Application Reference: 1026/0099

Site Address: 30 Coniston Drive, Bolton Upon Dearne, Barnsley, S63 8NE

Introduction: This application seeks full planning permission for a two storey side and rear extension to dwelling.

Drawing Title
Proposed right side elevation and neighbour view consideration

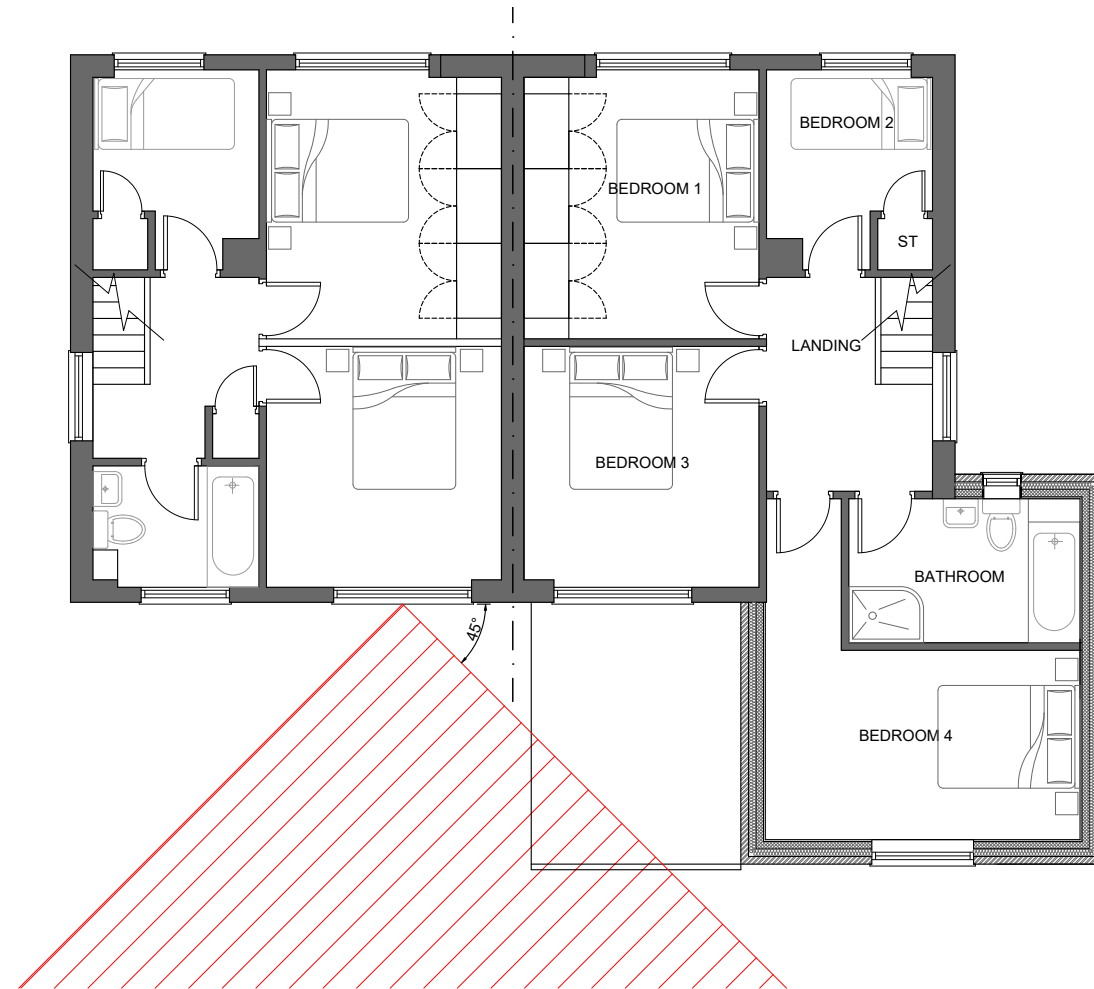
- Plan 159-003 was amended to 159-003 Rev A due to a minor omission of an existing roofline. The actual proposal was clearly shown and has not been amended.
